18 December 2023

RE: Non-Material amendment to PA22/03143 for minor changes to fenestration, brick and cladding specification, minor reduction in parapet height, relocation of the substation location and removal of pedestrian access.

**Land North Of Victoria Commercial Centre Victoria Business Park Roche Cornwall
PL26 8LX**

Title
Site Layout - Proposed Site Roof Plan

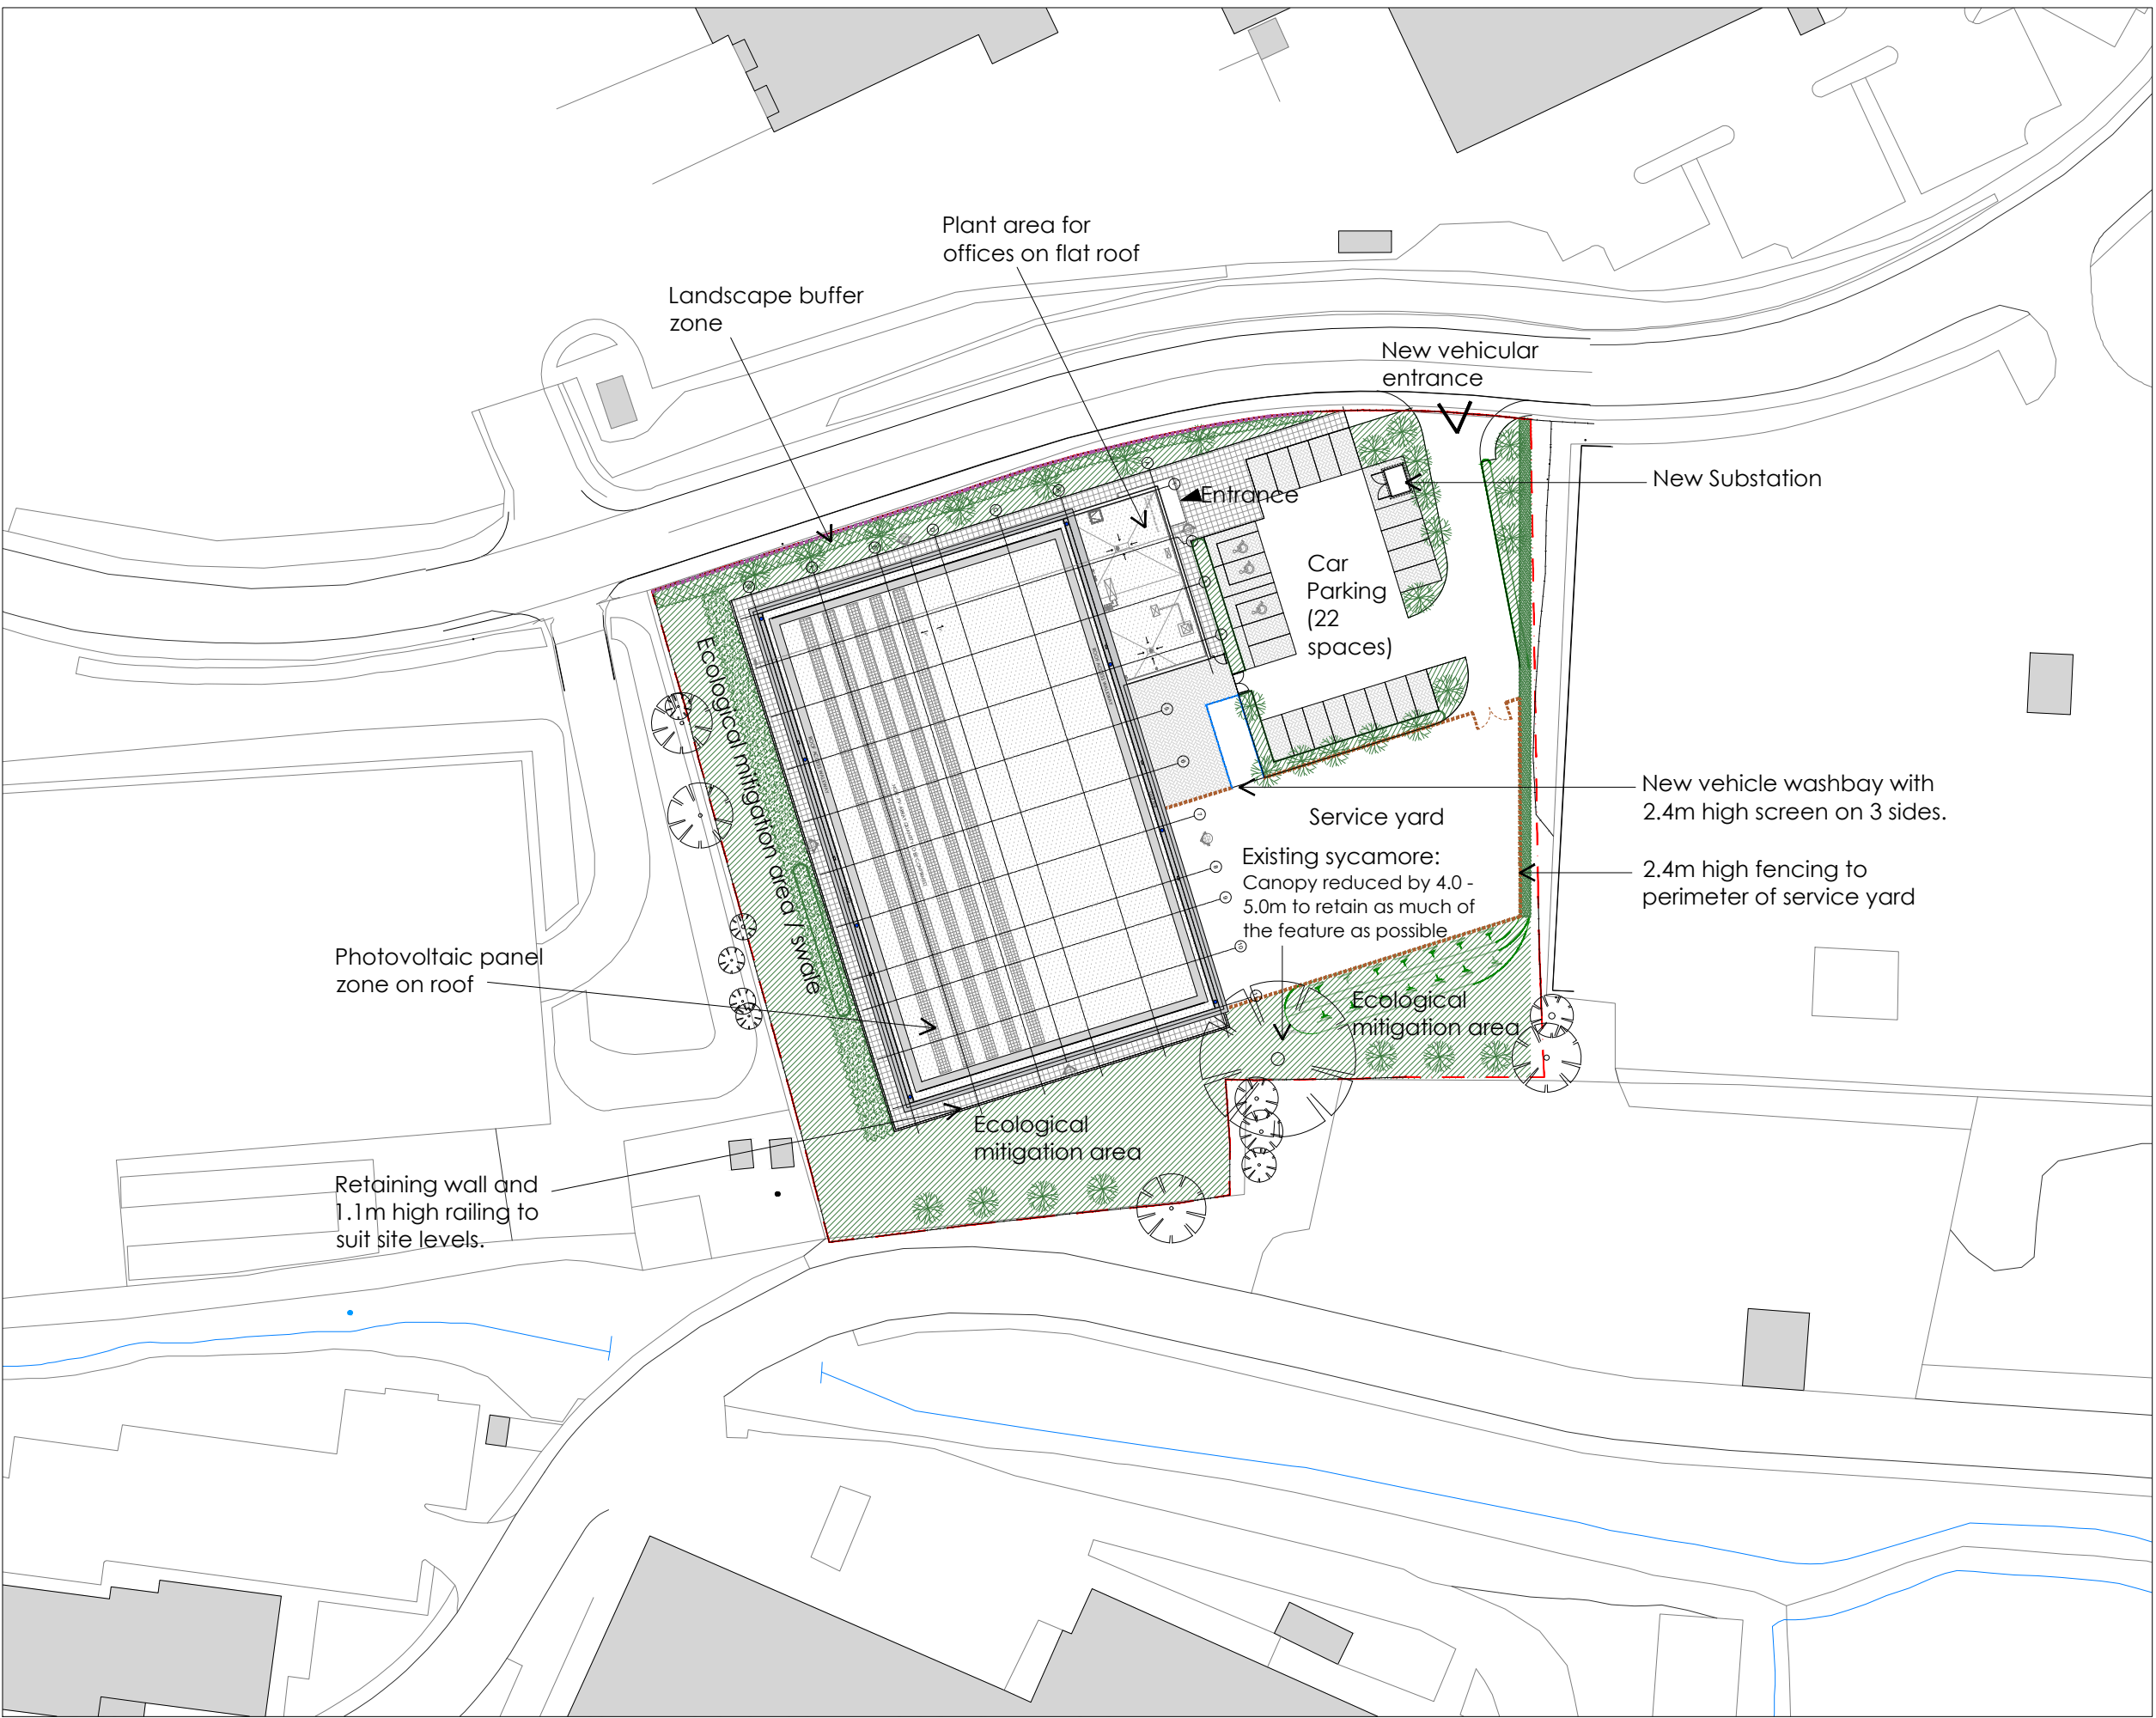
- Gable ends changed from flat to pitched parapets and long elevation parapets reduced in height. Ridge height increased due to change in cladding system and non-combustible insulation requirements.
- Building FFL reduced by 200mm (FFLs were not included at Planning stage).
- Substation relocated within car park area – no change in number of parking spaces as a result (still 22) or access arrangements.
- Removal of pedestrian access along western boundary to allay security and safety concerns expressed by the end user (DHL).

Title  
 Proposed Elevations  
 Sheet 1

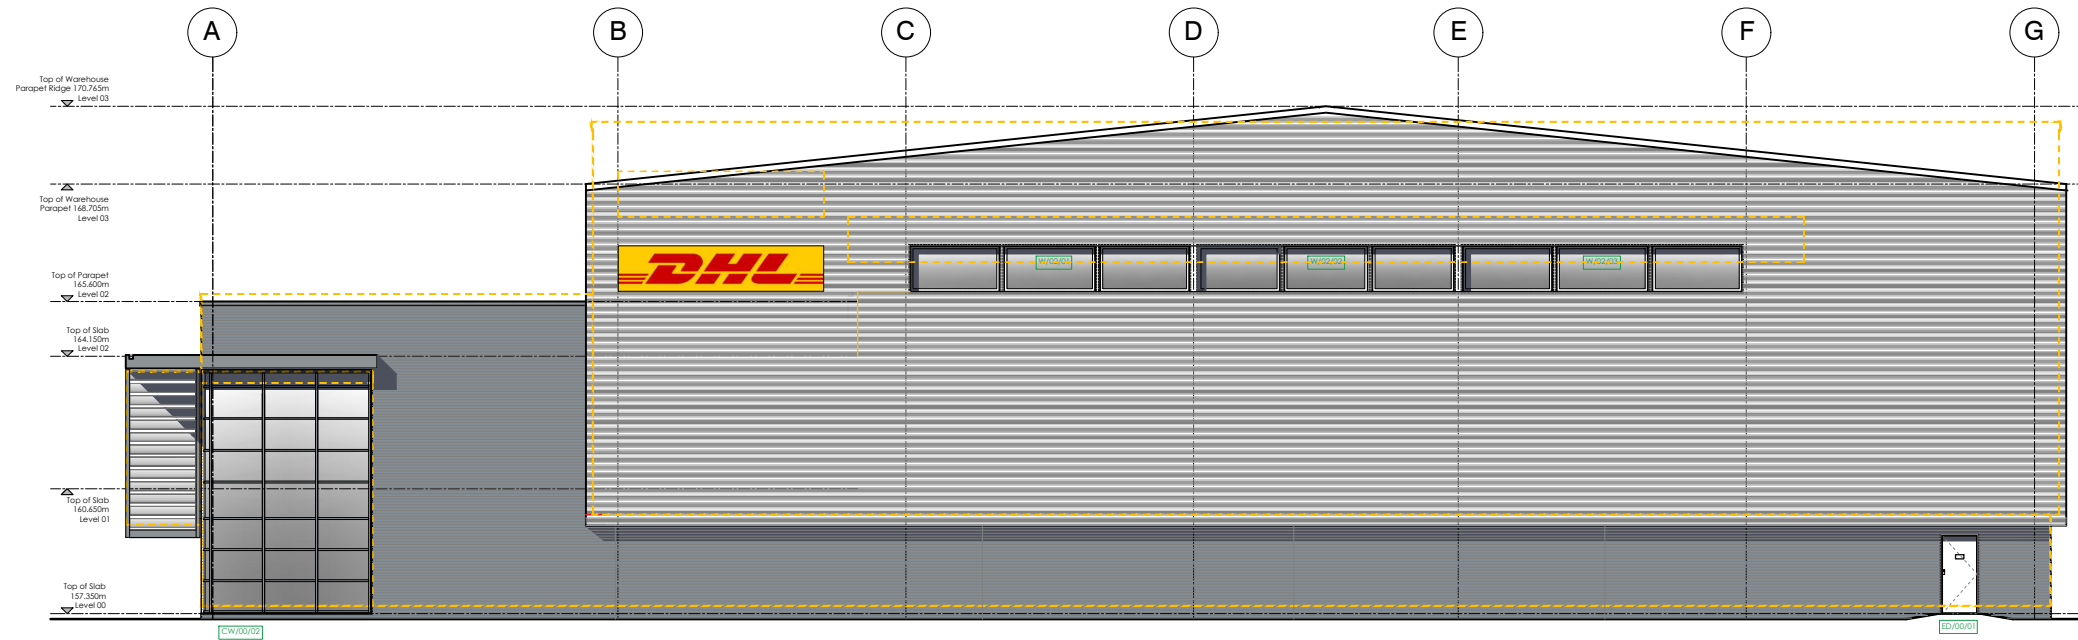
Amendment of brick spec from long format grey to standard format grey.

Amendment of cladding from smooth white panels to profiled white sheets.

Minor amendments to fenestration and louvre setting out.

Title
Site Layout - Proposed Site Plan

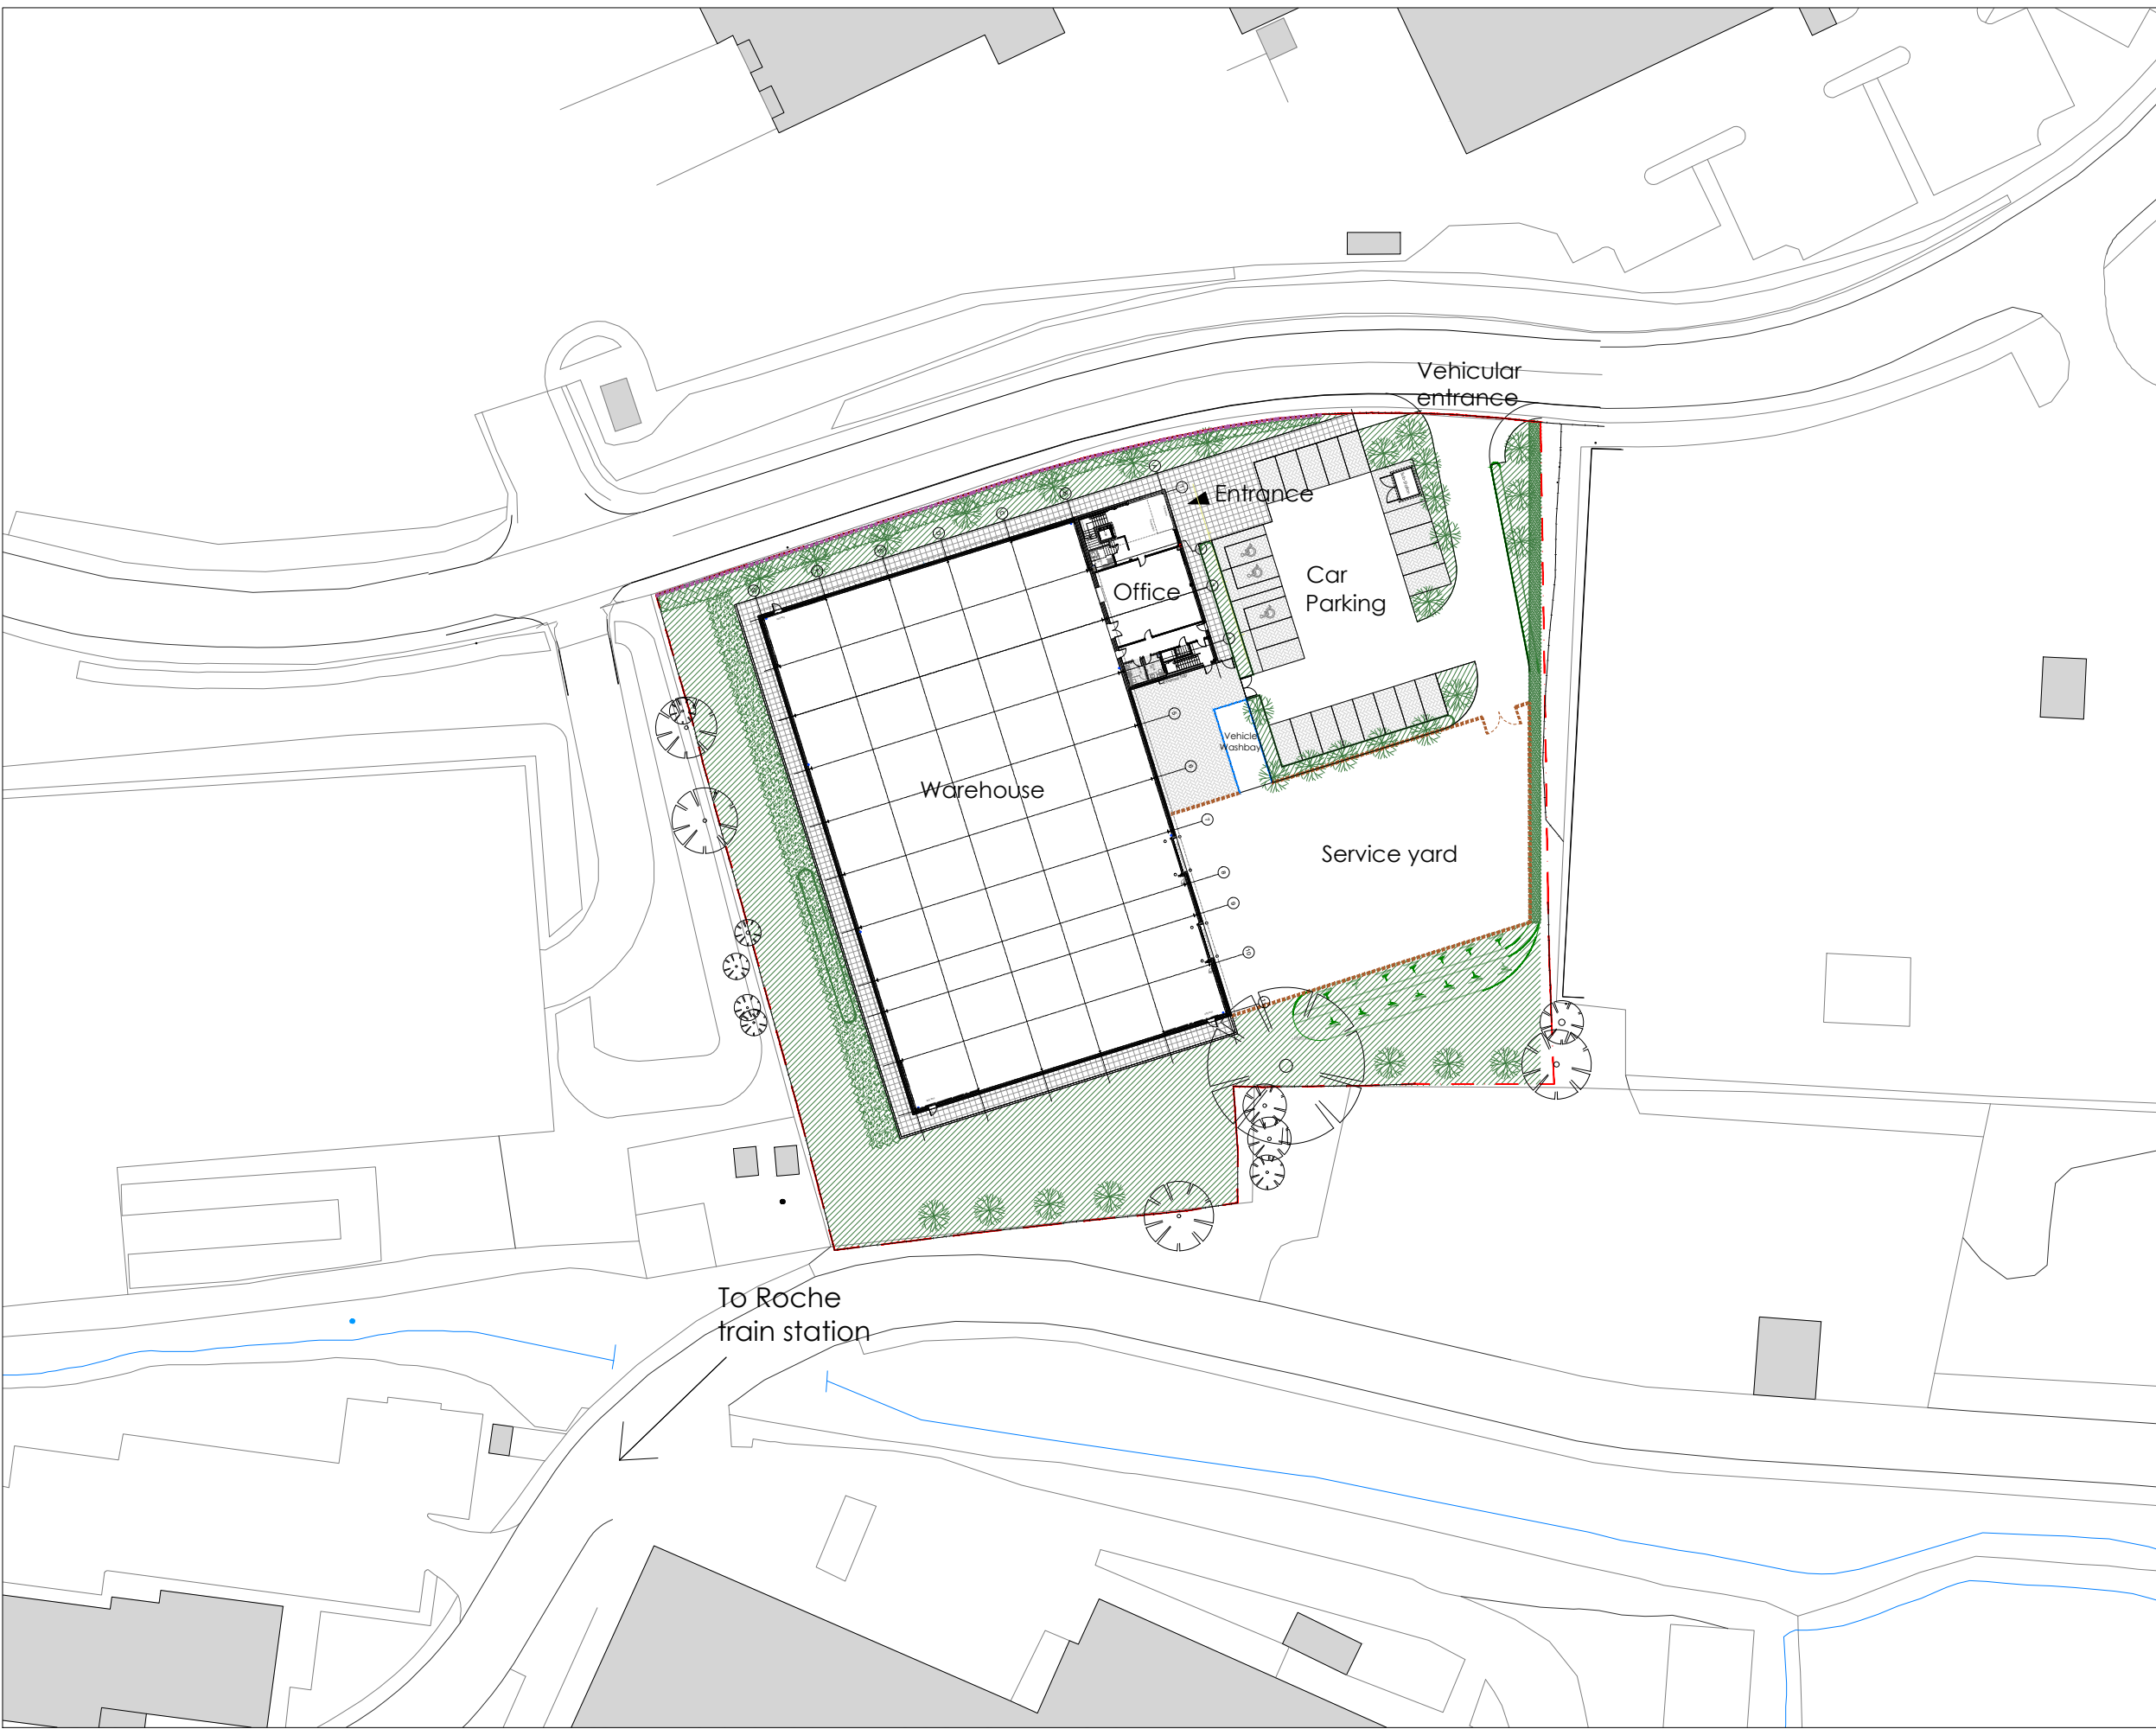
For the avoidance of doubt, the proposed relocation of the substation within the within the car park area will not impact on the approved number of parking spaces (22 in total) nor will it affect the approved access arrangements.

The removal of the pedestrian access along the western boundary access is proposed to ensure appropriate security and safety standards can be maintained. The proposed access was not a planning requirement or consideration during the determination of the extant permission and on this basis, it's removal would not have a bearing on the acceptability of the proposals overall and is considered a minor amendment.
